KIRKLEES METROPOLITAN COUNCIL INVESTMENT & REGENERATION SERVICE

DELEGATED DECISION FOR DISCHARGE OF CONDITION A1 - NOTIFICATION OF A PROPOSED DEVELOPMENT UNDER LOCAL OR PRIVATE ACTS OR ORDER

Reference no. 2026/CL/90201/W

Description	Prior approval for alterations to bridge Bridge MVL3/67 Low Westwood Lane, north of Linthwaite (within a Conservation Area)
--------------------	--

Drawing Title  
**Prior Approval - MVL3/67 Low Westwood Lane - Existing and Proposed Elevation and Section**

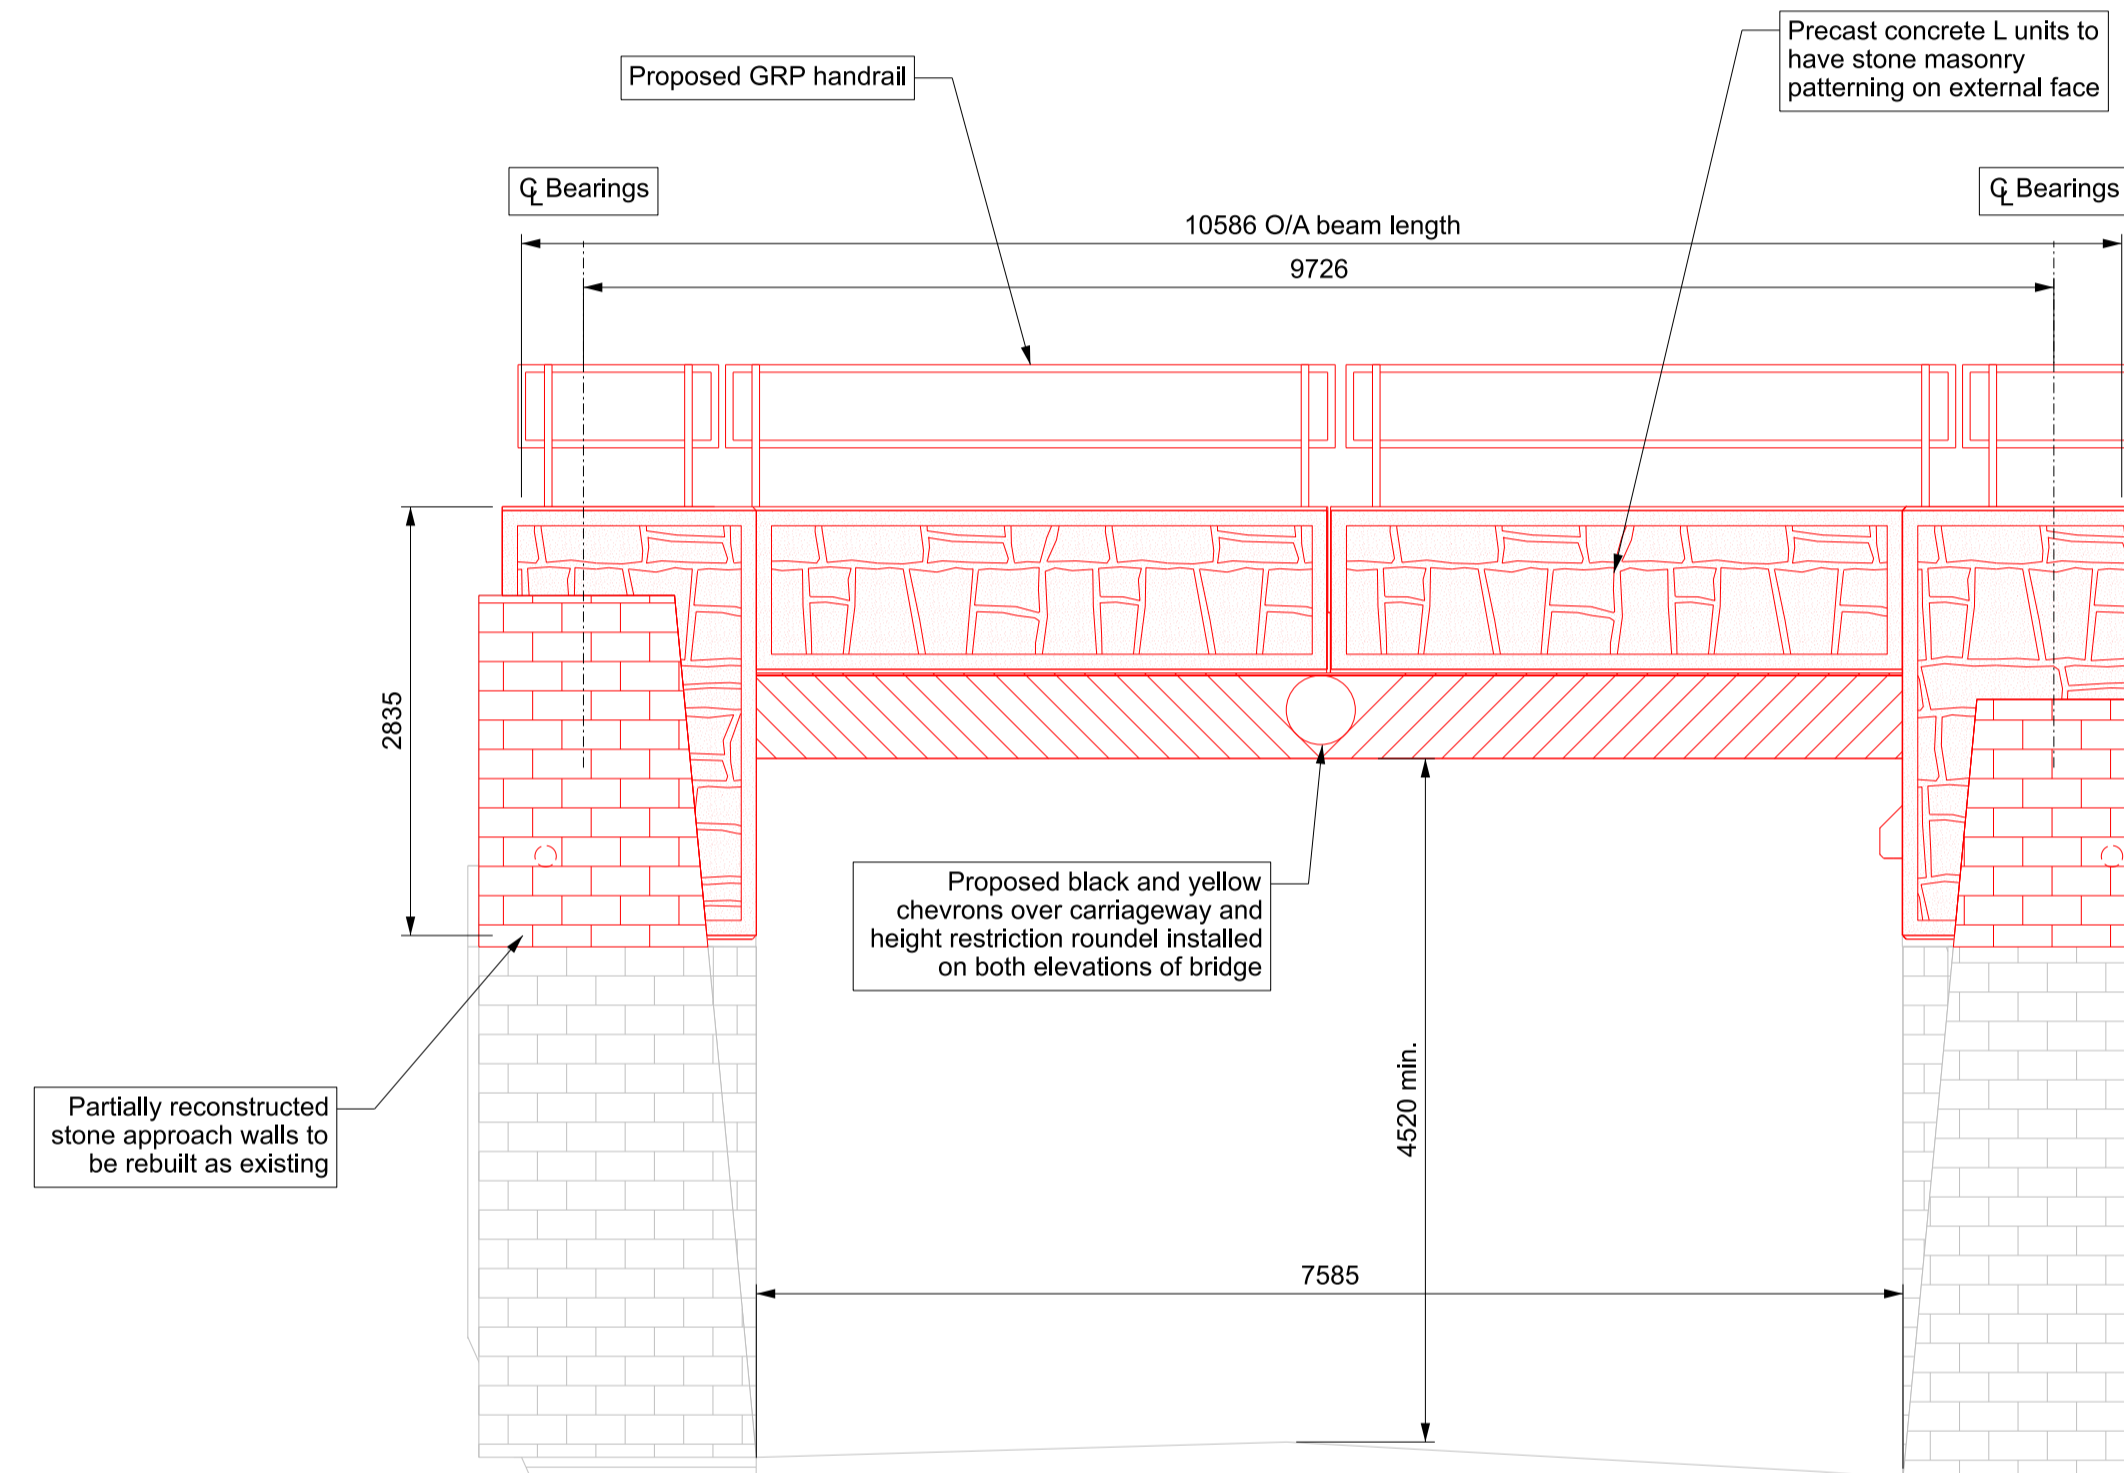
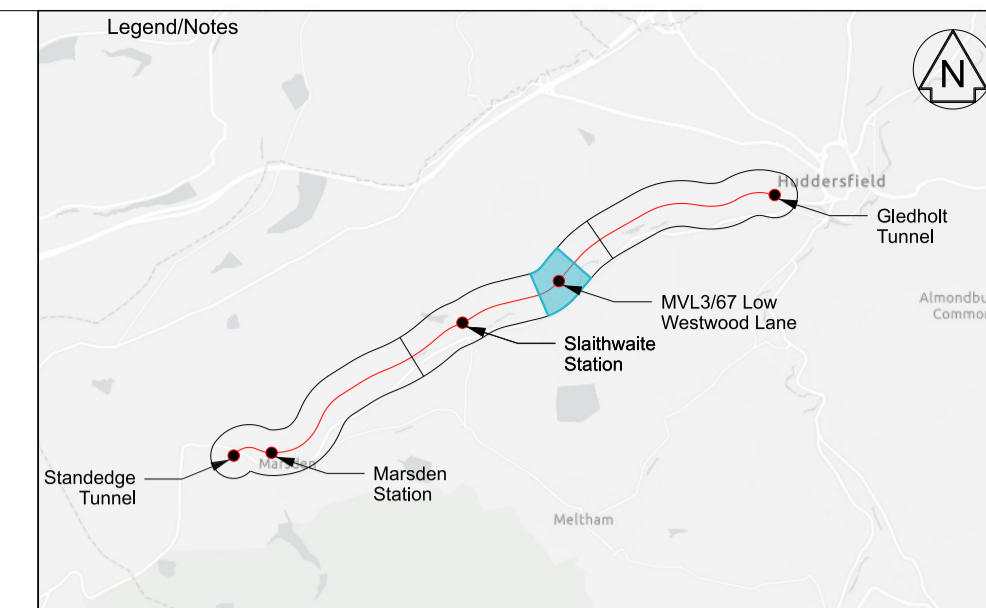
The proposed works are required to accommodate the introduction of a third track across the bridge and include the wrought iron bridge decks with concrete deck beams, and the replacement of the existing metallic parapet, stone copers and pilasters with pre-cast concrete units (using stone masonry patterning) and GRP handrails.

- *The pre-cast concrete L-units shall be finished with natural stone cladding design pattern to match the natural coursed stones below. The concrete shall match the existing natural stones by colour, texture and coursing.*
- *The GRP handrail shall be finished in a black or green colour*

Due to its minimal heritage interest from a typical design and extent of alterations, the bridge is not considered to be a non-designated heritage asset. The southern part of the bridge lies within the northwestern boundary of the Linthwaite Conservation Area. The northern façade of the bridge is located within the Wellhouse Conservation Area. The northern façade of the bridge faces a sharp bend in Low Westwood Lane and is screened on both sides by steep embankments, meaning the bridge is only visible from Low Westwood Lane and the immediate north. Given the topography of the site and limited contribution of the bridge to the conservation Areas (located on the boundary of both and the structure itself not included within either), the proposed works would have a neutral impact on the historic and architectural interests of the Linthwaite Conservation Areas. The southern façade will remain as existing, as such there is no considered impact to Linthwaite Conservation Area. Conservation and

Design officers have requested a condition for the submission of the parapet finish materials and design. As such, there is no objection to the proposed works, subject to the application of suitably worded conditions for the submission of parapet materials and design and the finish of the proposed handrails.

In respect of other matters, it is proposed the soffit height and minimum clearance of the existing bridge would be increased on the new structure (from 4.462m to 4.520m), and there would be no alterations to the highway. The granting of prior approval under Part 18 of the GPDO would not grant consent to undertake these works without other necessary consents being sought and in place (eg, temporary closure of public right of way).

1. Notwithstanding the submitted plans, a sample of the parapet finish[es] shall be submitted to and approved by the Local Planning Authority, prior to their installation. The external treatment of the parapet finish[es] shall reflect the retained stonework of the bridge in terms of colour, texture, finish and coursing.

2. The GRP handrail shall be finished in a black or green powder coating.
